EPC STORMWATER REVIEW COMMENTS ARE SHOWN IN ORANGE BOXES WITH BLACK TEXT

2022 Financial Assurance Estimate Form
(with pre-plat construction)

PROJECT INFORMATION		
Saddlehorn Ranch Filing 2 Improvements Early Grading	5/12/2022	EGP221
Project Name	Date	PCD File No.

EARLY GRADING
IMPROVEMENTS

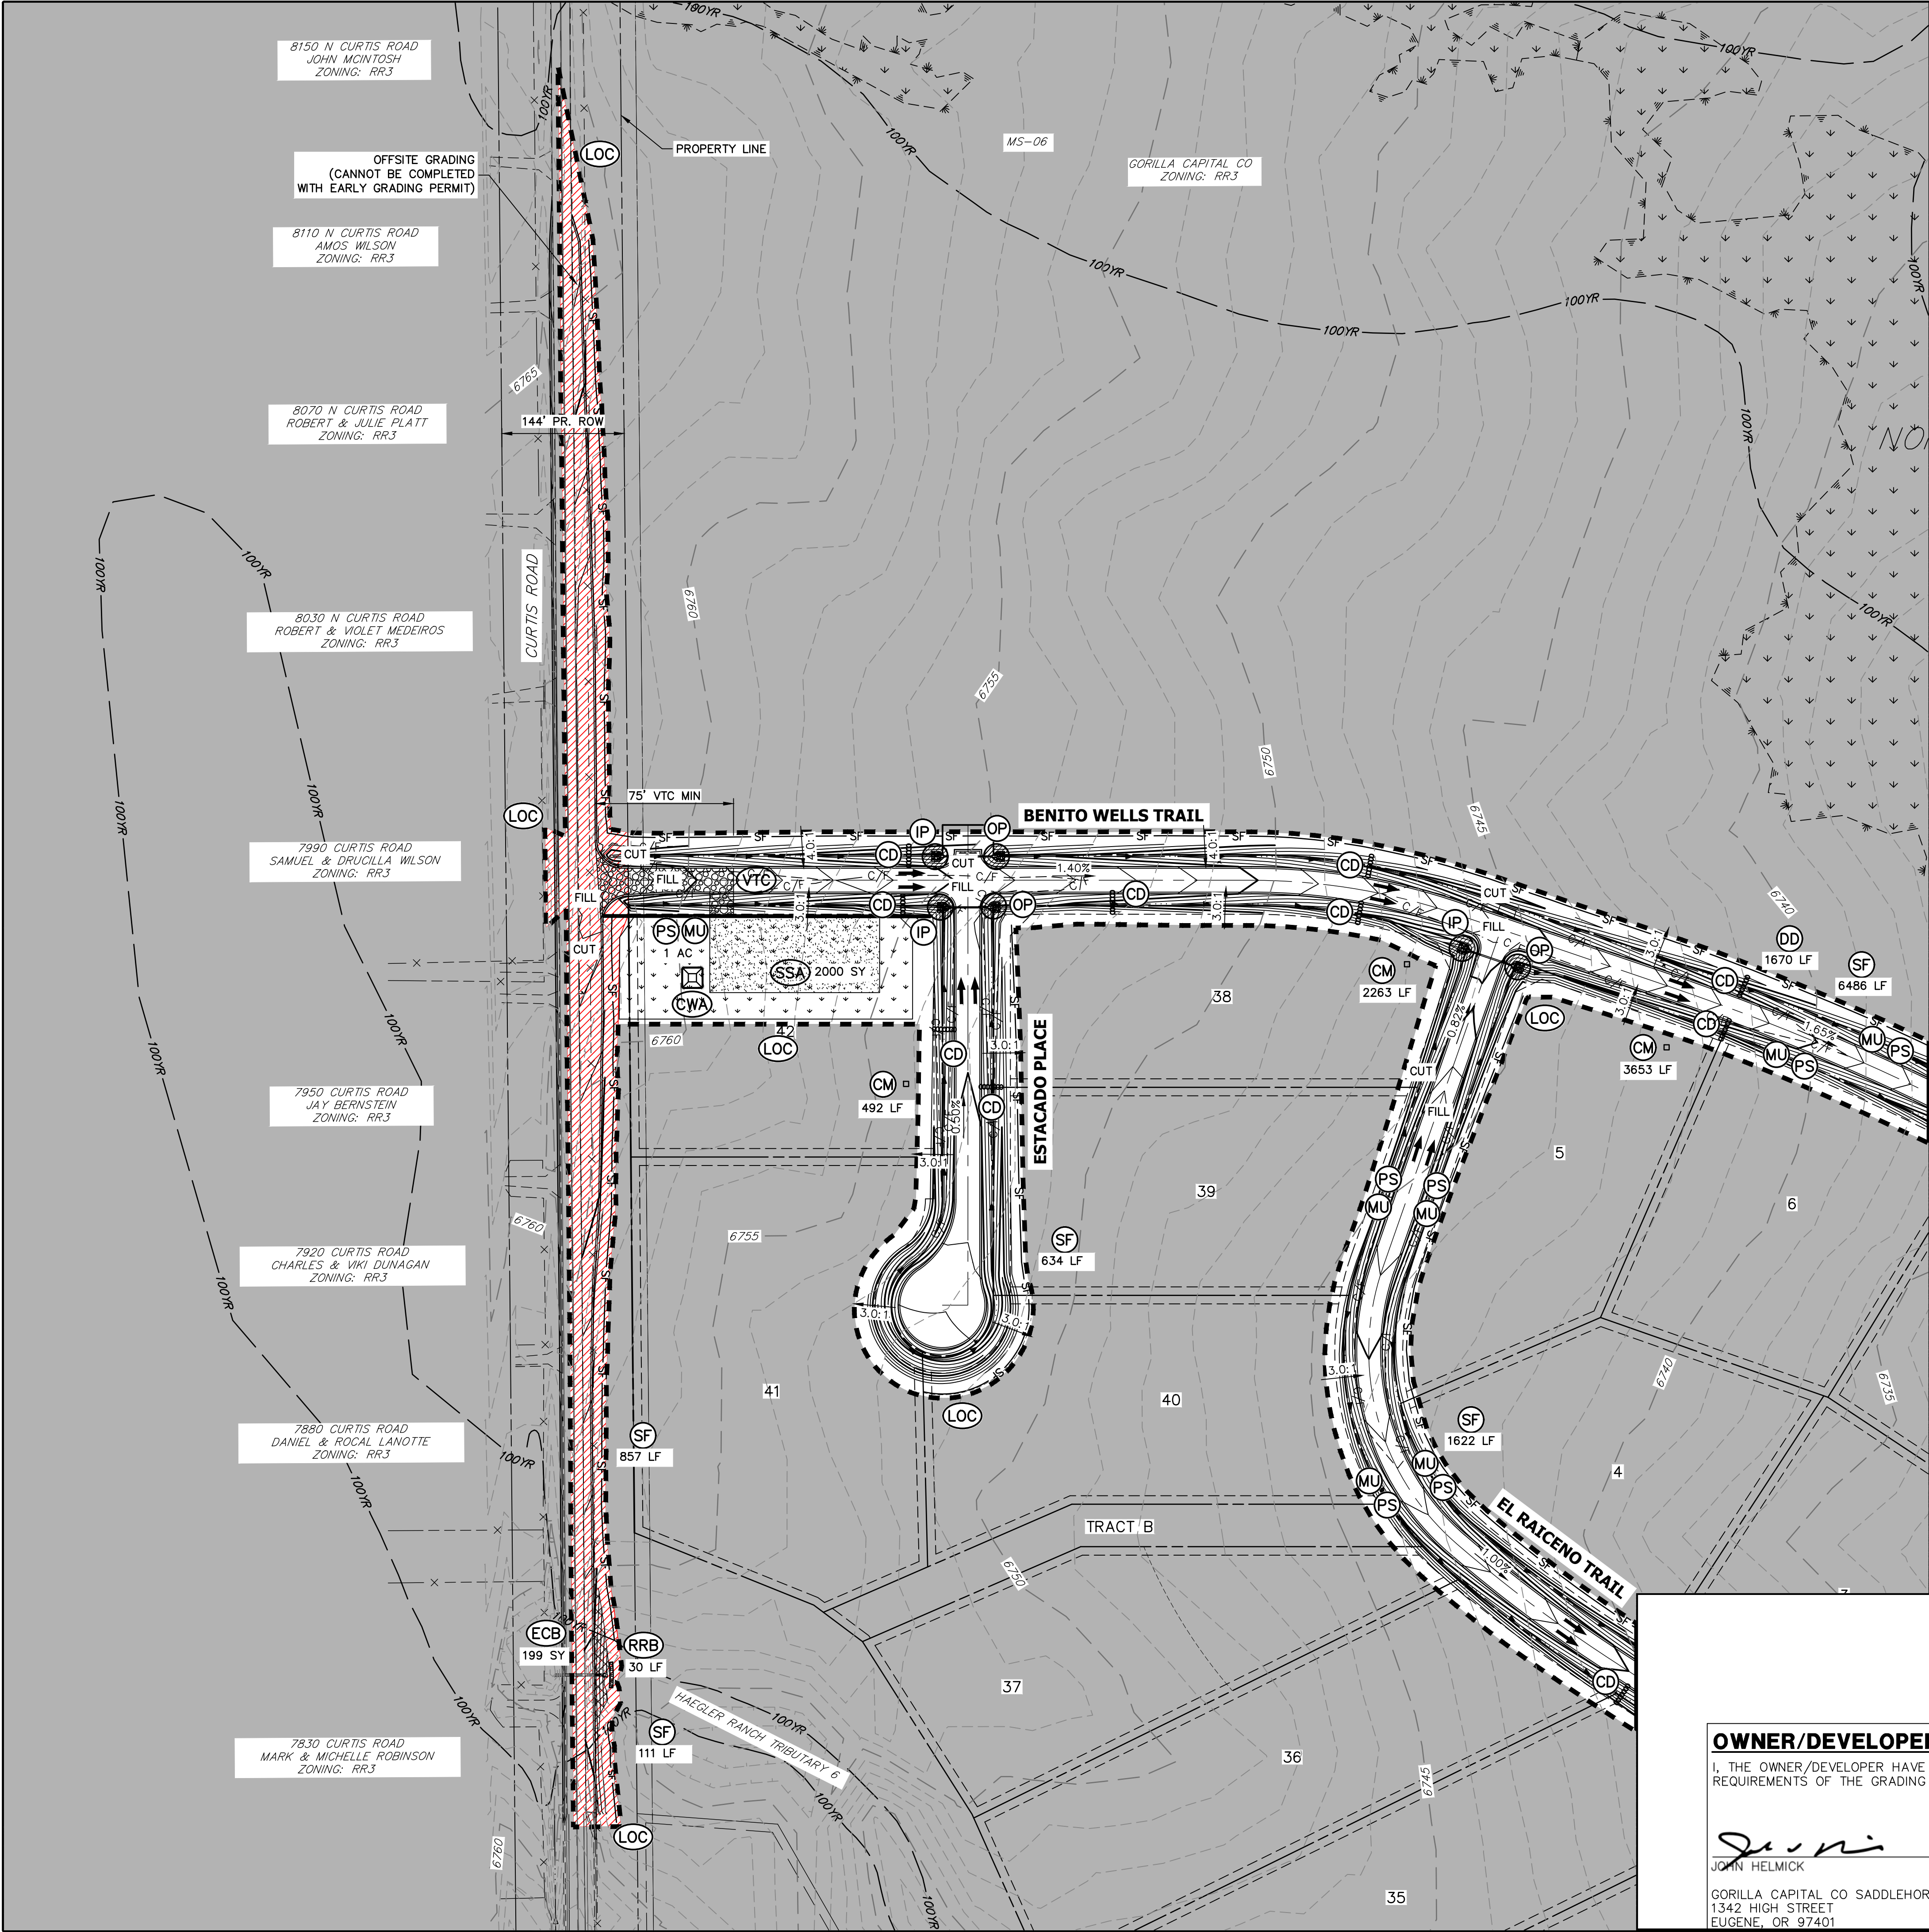
Add the following items since these are shown on the GEC and/or noted as being constructed in the FDR narrative:
 - Pond F forebay
 - Emergency Spillway
 - Pond outfall spreader/riprap
 - Riprap rundown into the forebay
 - Trickle Channel
 - Concrete Washout Basin

JR: None of the following items will be constructed with Sediment basin 1 at the time of early grading. The items have been removed from the Early Grading GEC Plans. They are only mentioned in the Early Grading FDR narrative to explain the future of sediment basin 1 once the project progresses past early grading.
